**Development Review Board (DRB)
Review Comments
Utility Development Section
Reviewer: Kristopher Cadena, P.E.
Phone: 505.289.3301**

DRB Project No: PR-2019-002184	Date: 01/15/20	Item No: #4
Zone Atlas Page: F-21	Legal Description: Lot(s) TR G-1 PLAT OF TRACTS F-1 & G-1, ACADEMY PLACE SUBDIVISION Location: 4909 JUAN TABO BLVD NE between OSUNA RD and MONTGOMERY BLVD	
Request For: SI-2019-00379 – SITE PLAN

SHEET TITLE: CONCEPTUAL DRAINAGE PLAN

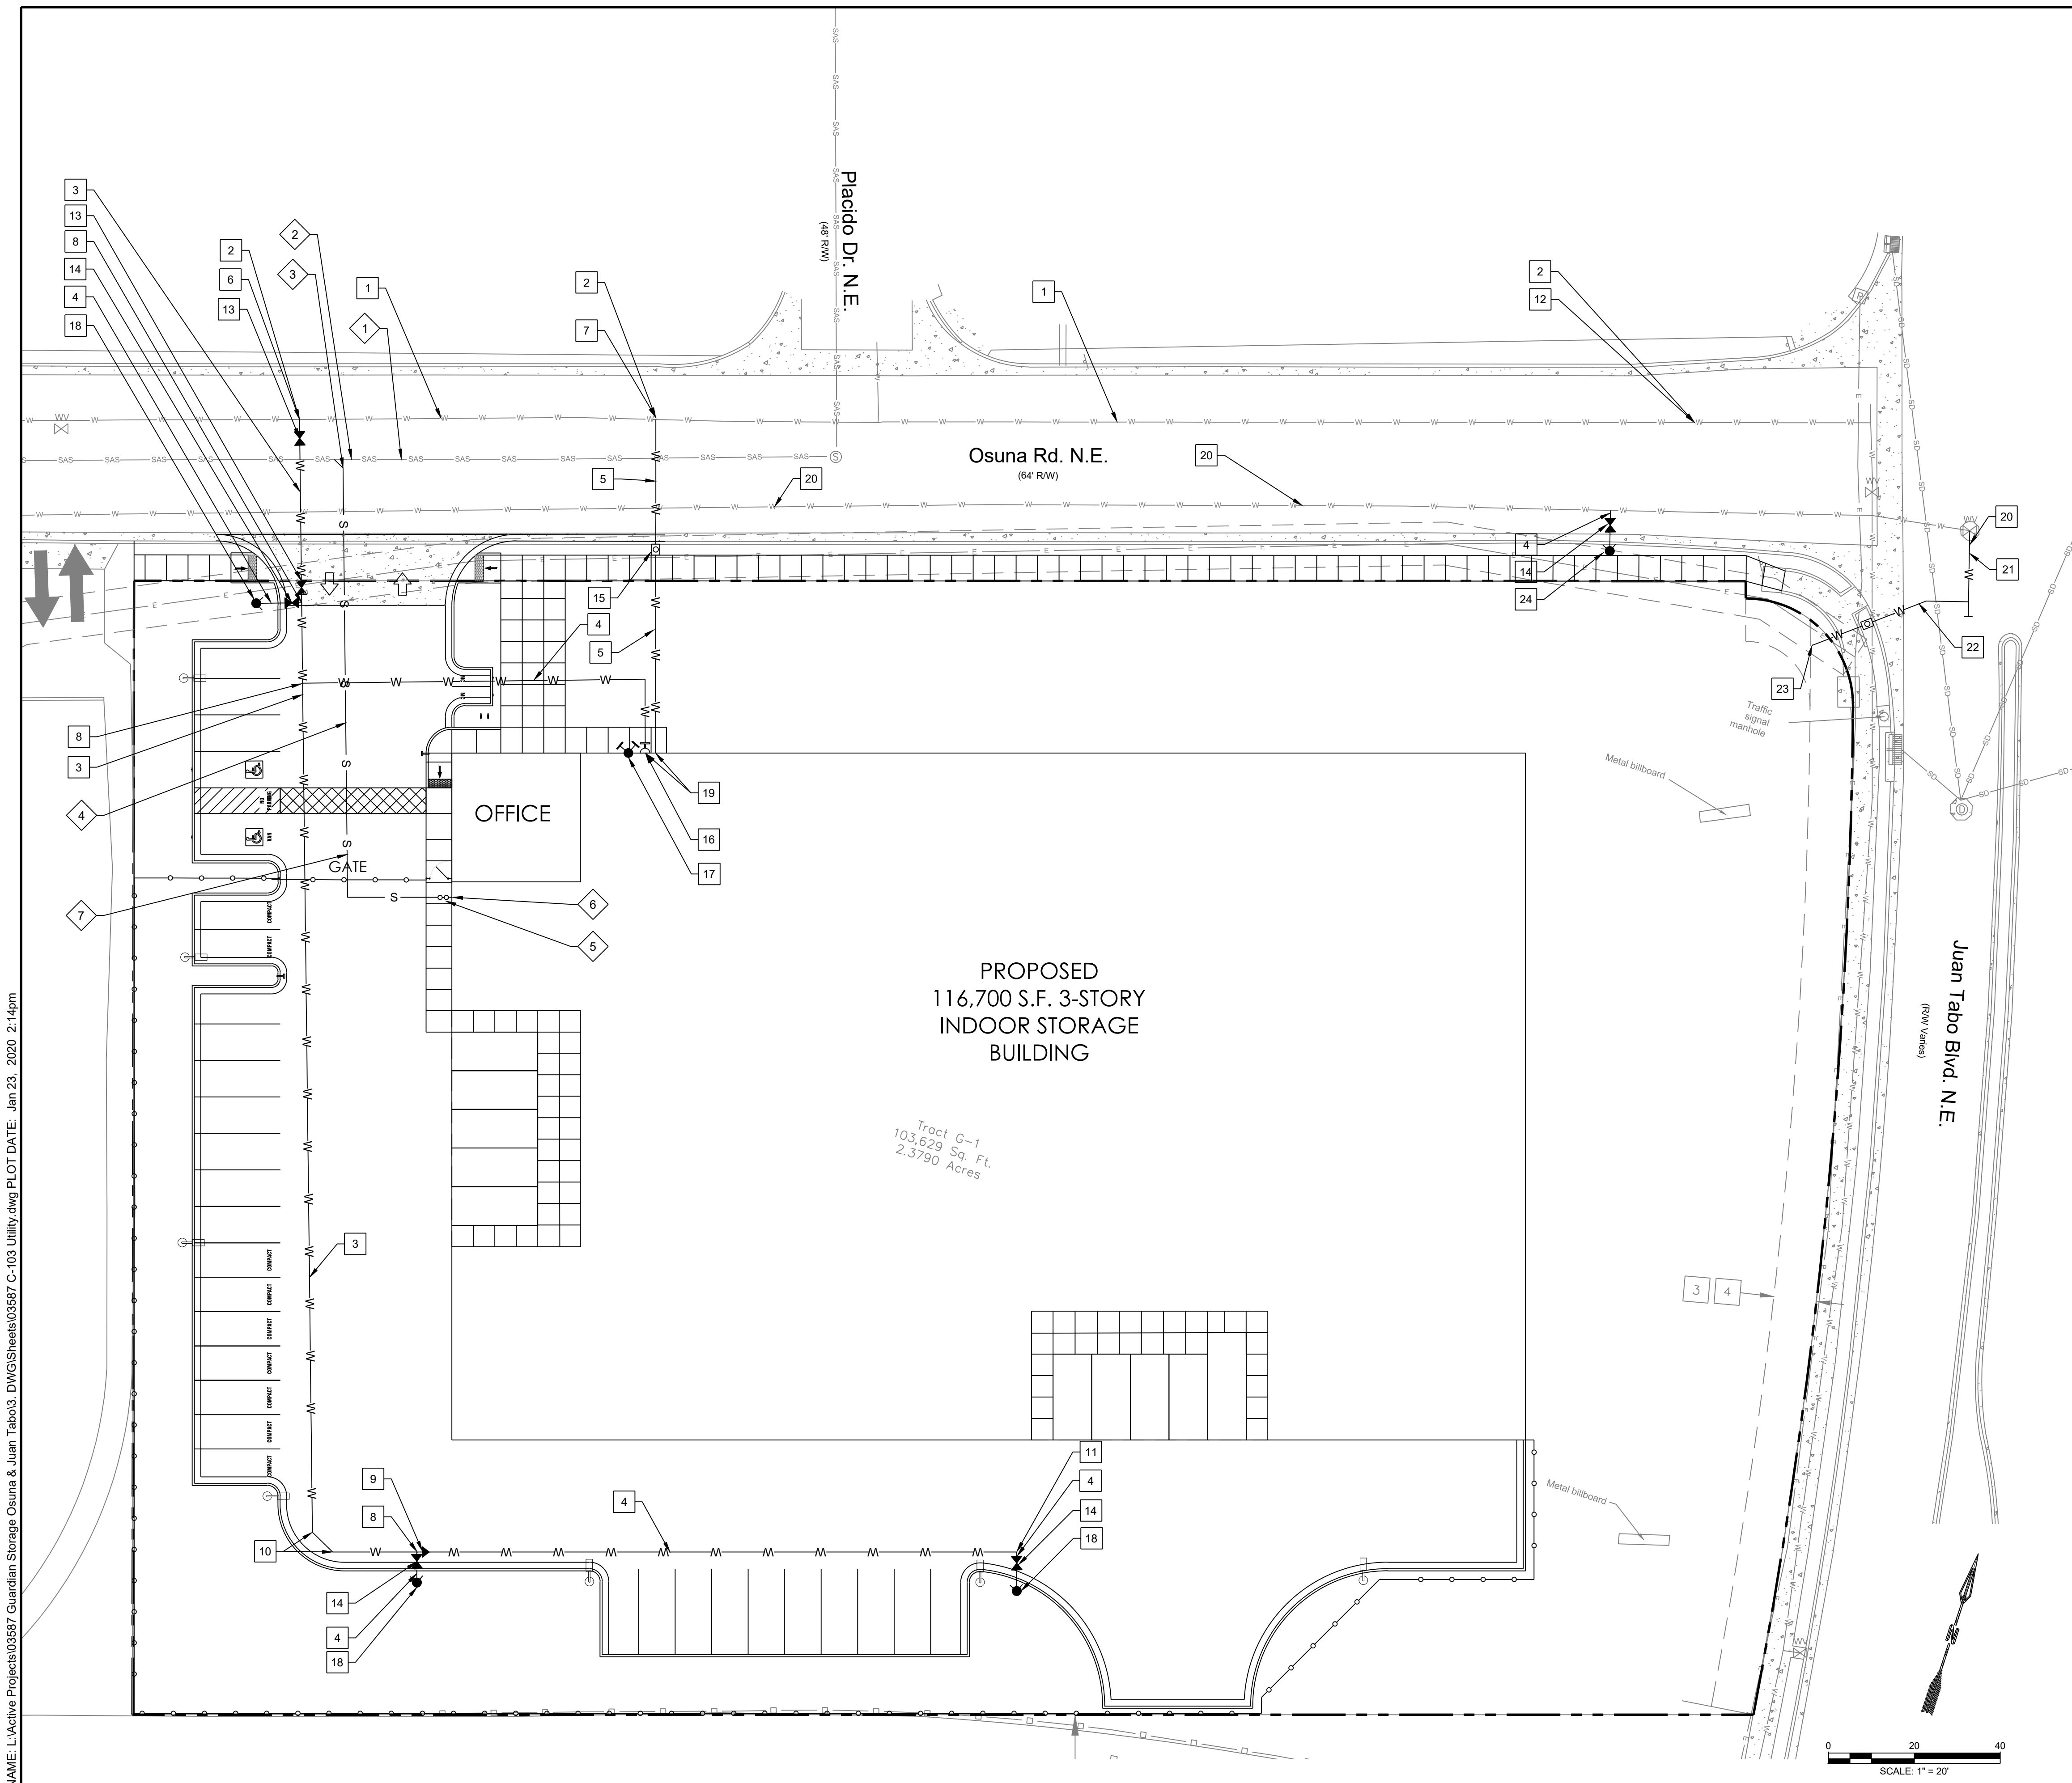
3. In previous correspondence, the engineer has stated that historically, the subject site flows west across the existing Water Authority property. Based on the conceptual grading plan, the entire property had an existing flow rate of 4.54 cfs. How much of this historically flowed across the Water Authority property? Is it understood to be the entire 4.54 cfs? The proposed condition appears to lessen the flow on the Water Authority property as proposed Subbasin B is what is shown to discharge on the Water Authority site with a flow rate of 0.29 cfs. Please confirm.
 - a. Somewhat steep slopes are being proposed along the western property line. What improvements will be done to minimize erosion on the Water Authority property?
4. For information only.
 - a. Availability statement #190317 provides the conditions for service.

SHEET TITLE: **CONCEPTUAL UTILITY PLAN**

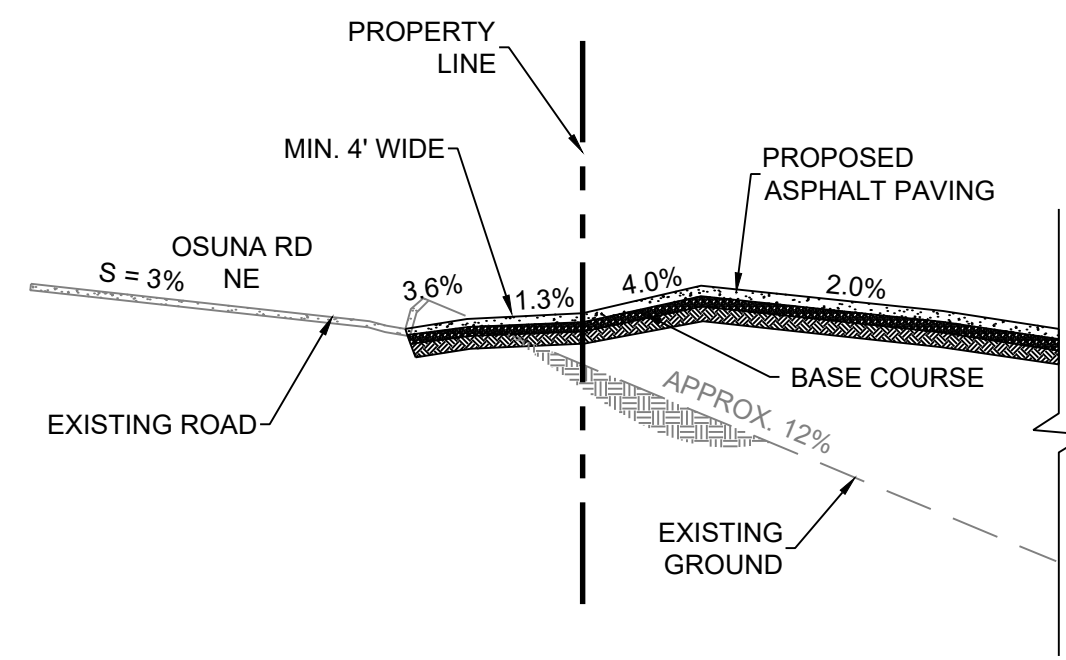
1. Per the Expansion Policy, newly developed properties shall connect to public waterline, reuse and sanitary sewer if within 200'. The proposed utility plan indicates a single water meter. Is this to be also be used for irrigation? If an irrigation meter is proposed, it shall connect to the existing 8" non-potable line along Juan Tabo Blvd. The expected pressure has been confirmed by Operations to range from 106 psi to 125 psi, and up to 150 psi during pump start up.
 - a. The service connection to the existing 8" non-potable line shall be included on an infrastructure list.
2. Please indicate which fire hydrants are public or private. Onsite fire hydrants shall be labeled as private. Proposed fire hydrants located within the public right-of-way are to be public.
